Application No: R/60/22/PL
Site Address: The Windmill Inn Mill Lane Rustington BN16 3JN
Description of works: Extension and remodelling of existing public house to form hotel with 20 No bedrooms and associated parking and landscaping. This site is in CIL Zone 4 (Zero Rated) as other development.

Thank you for your internet representation made on 20th April 2022 which has been recorded as support with the comments as follows:

DRAWING TITLE
Proposed Ground & First Floor Plans

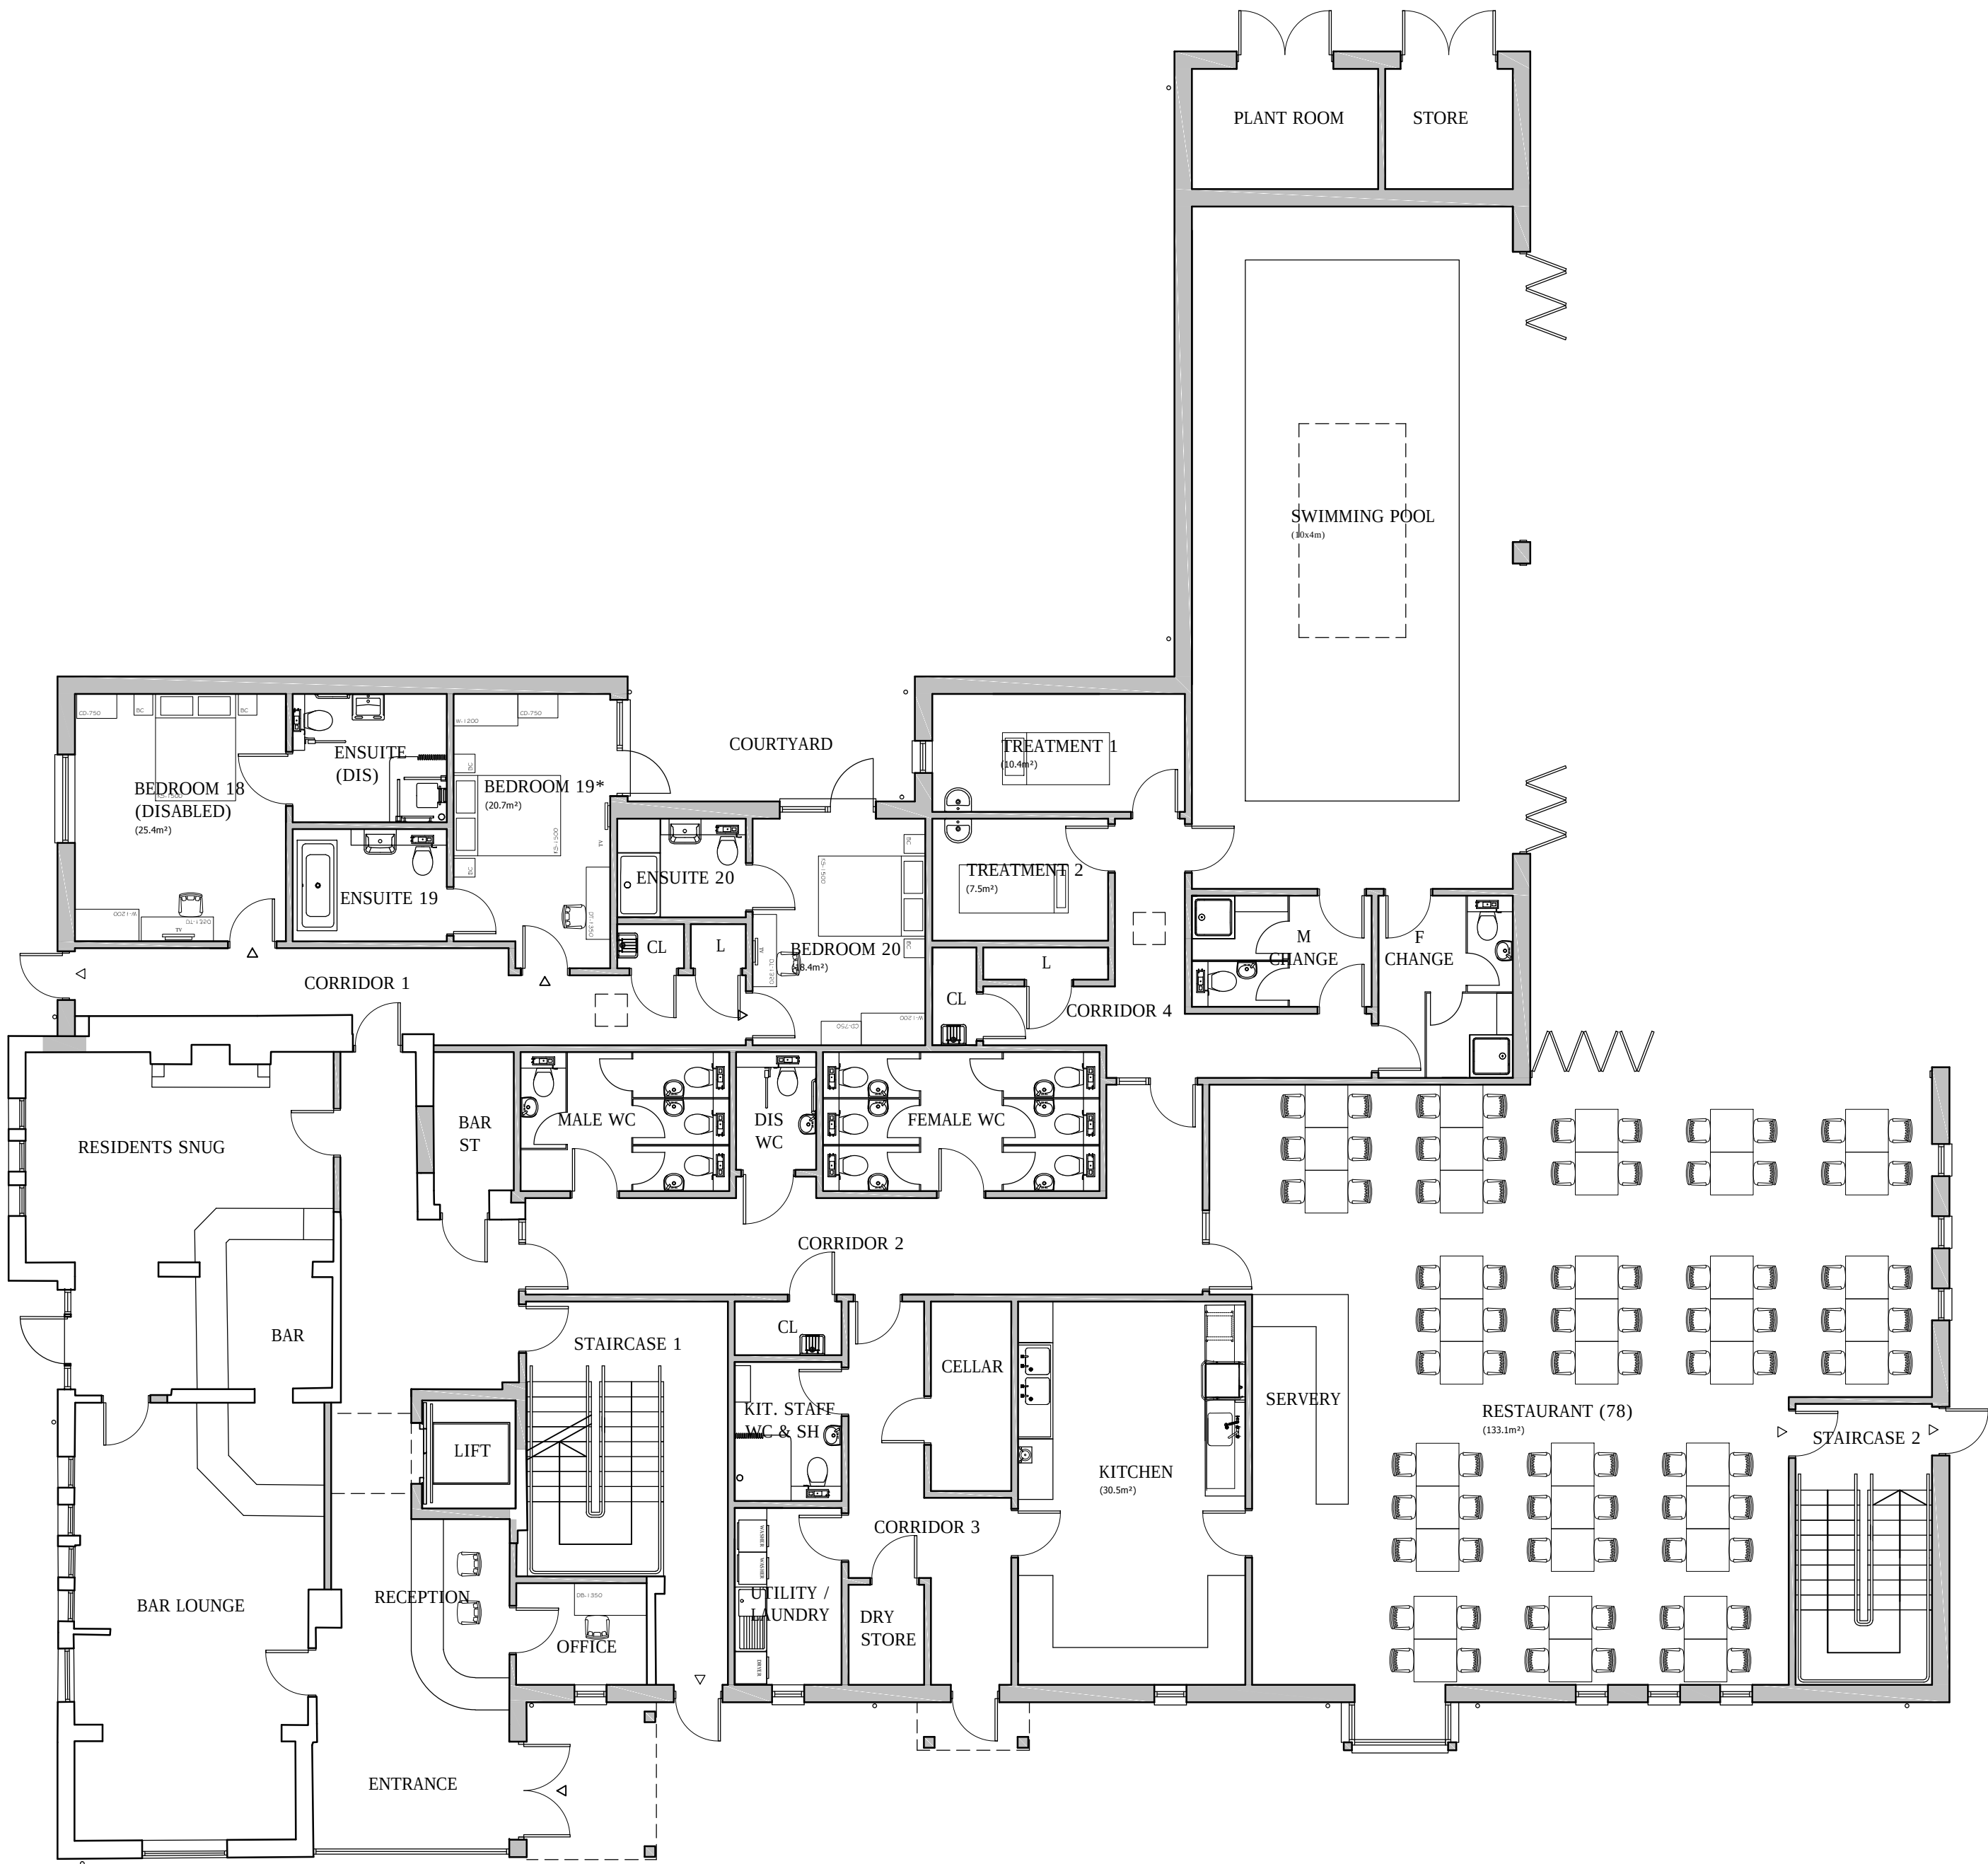
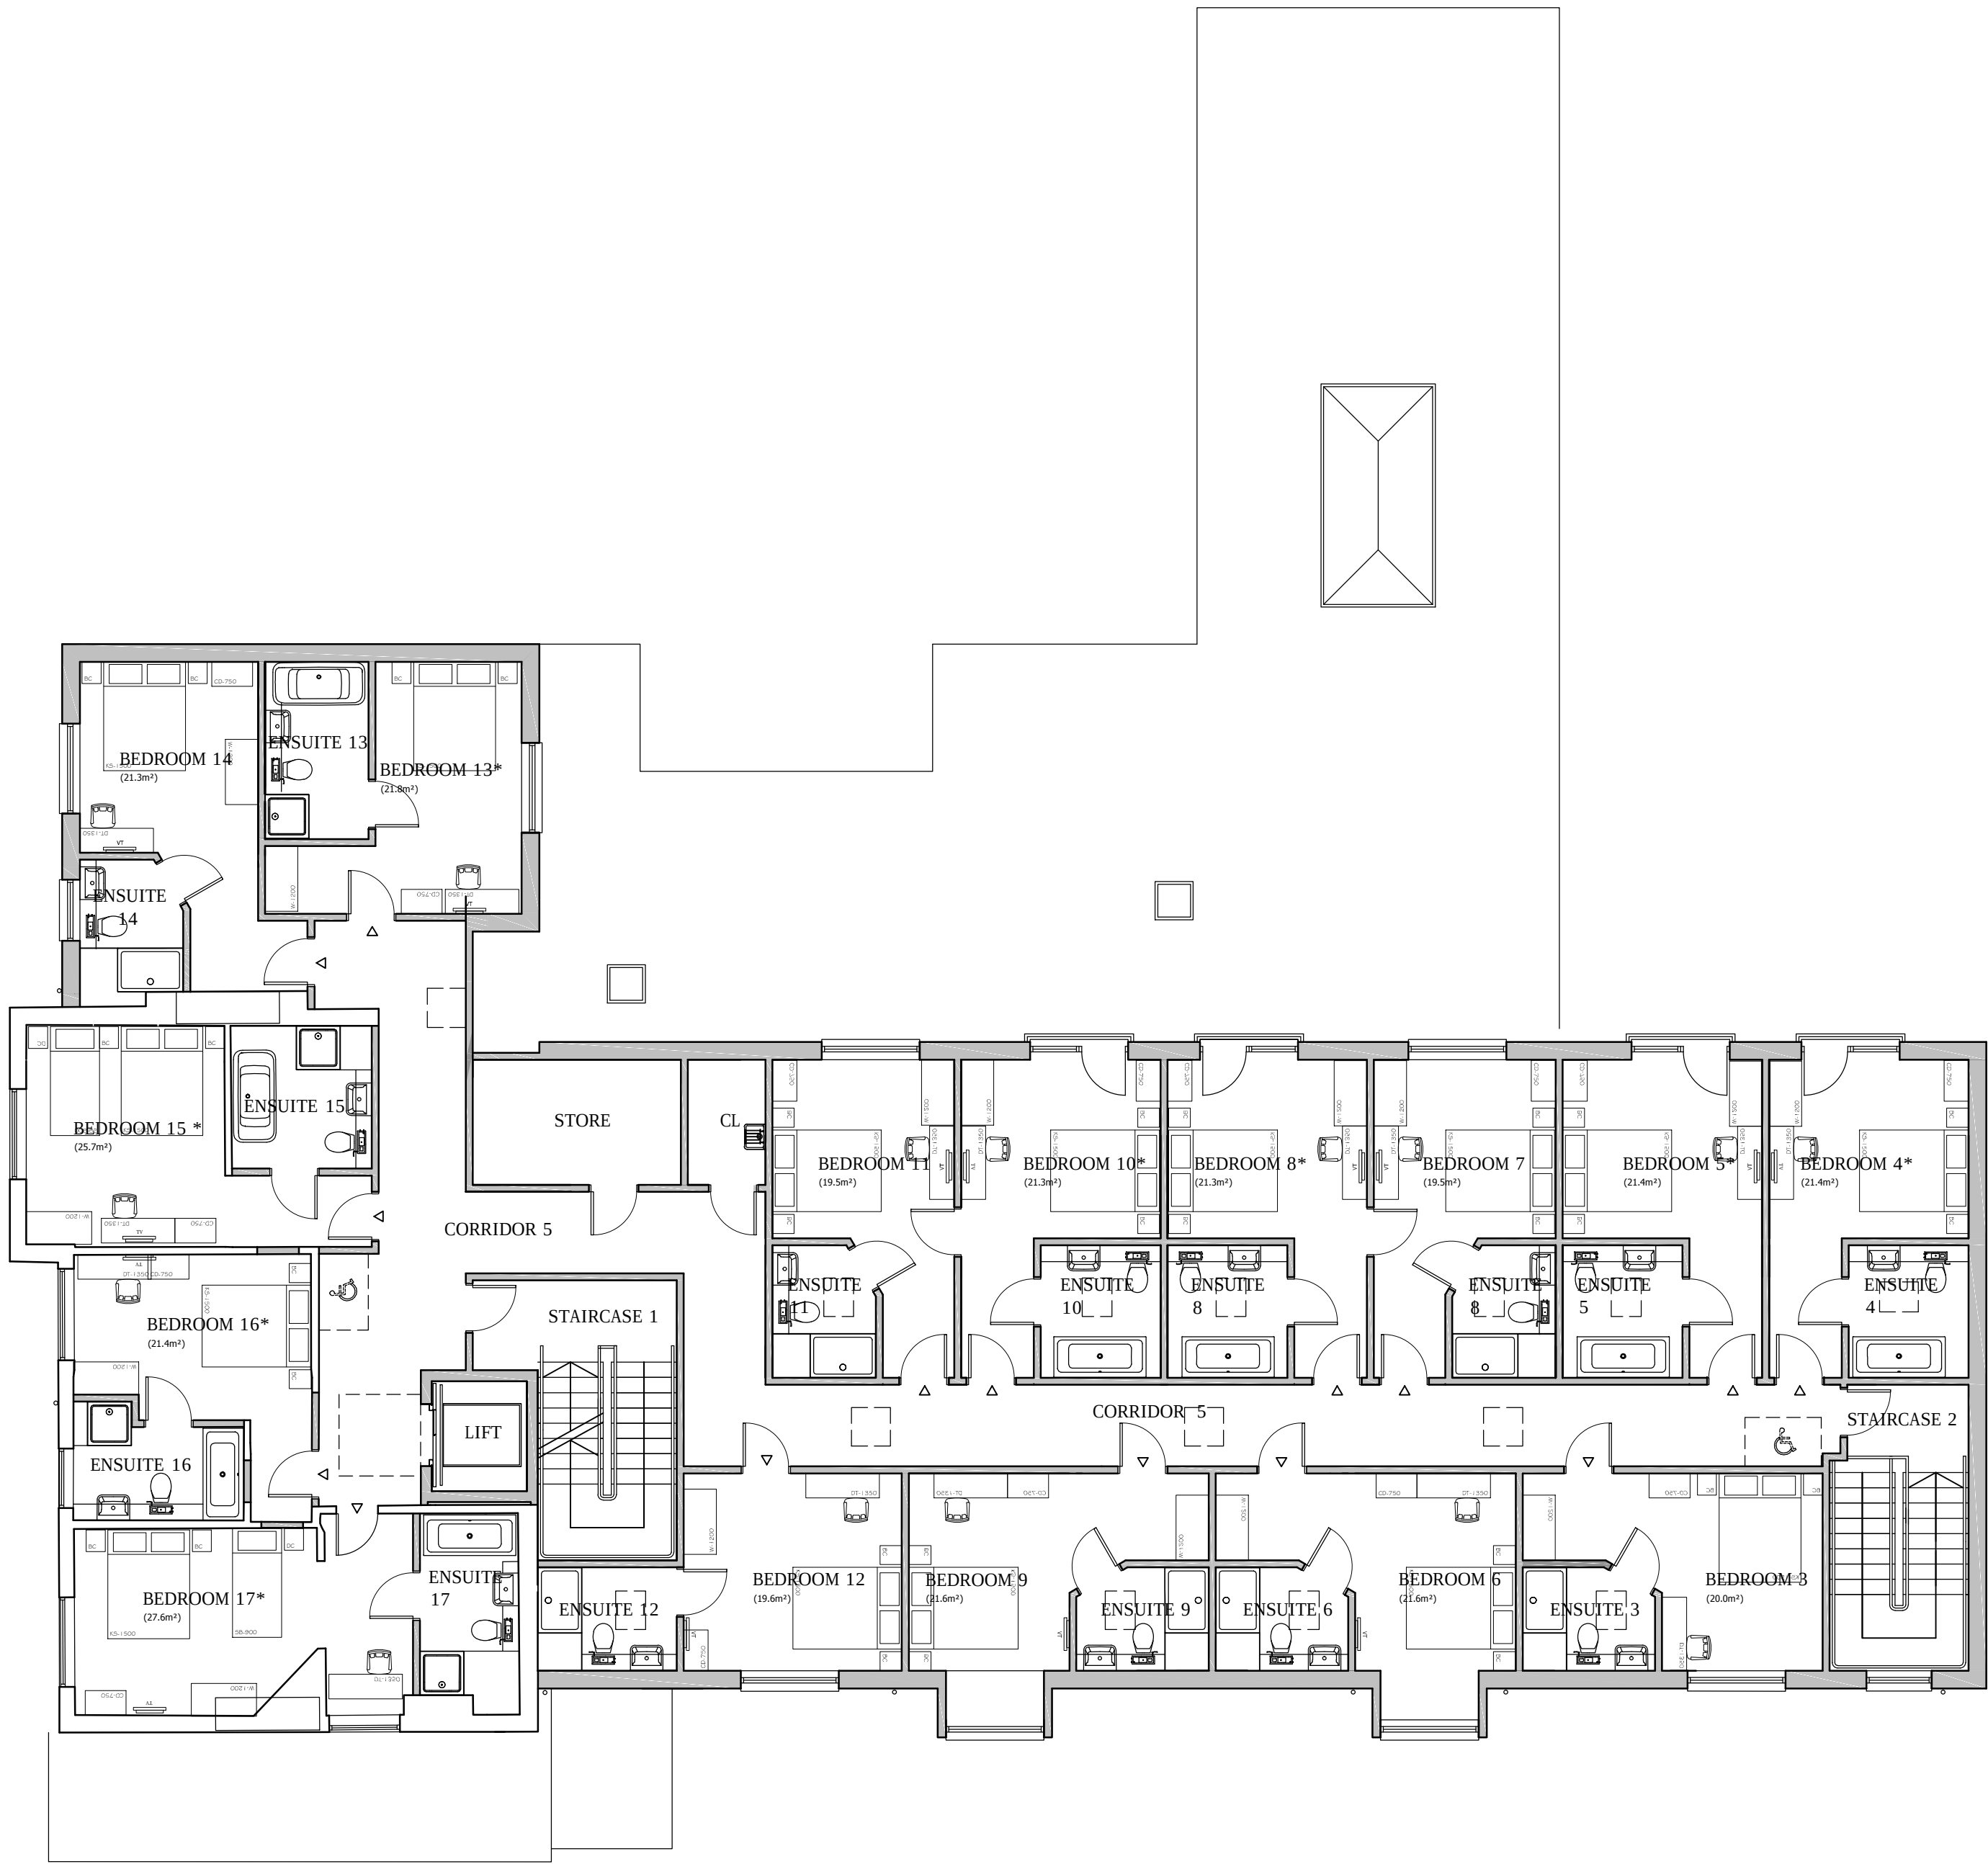
Our only concern is the north elevation which has 6 full length windows/doors looking down our garden. Maybe the light to these rooms could be via a Velux window and screen/wall on the flat roof area for our privacy. You're more than welcome to view from our garden.
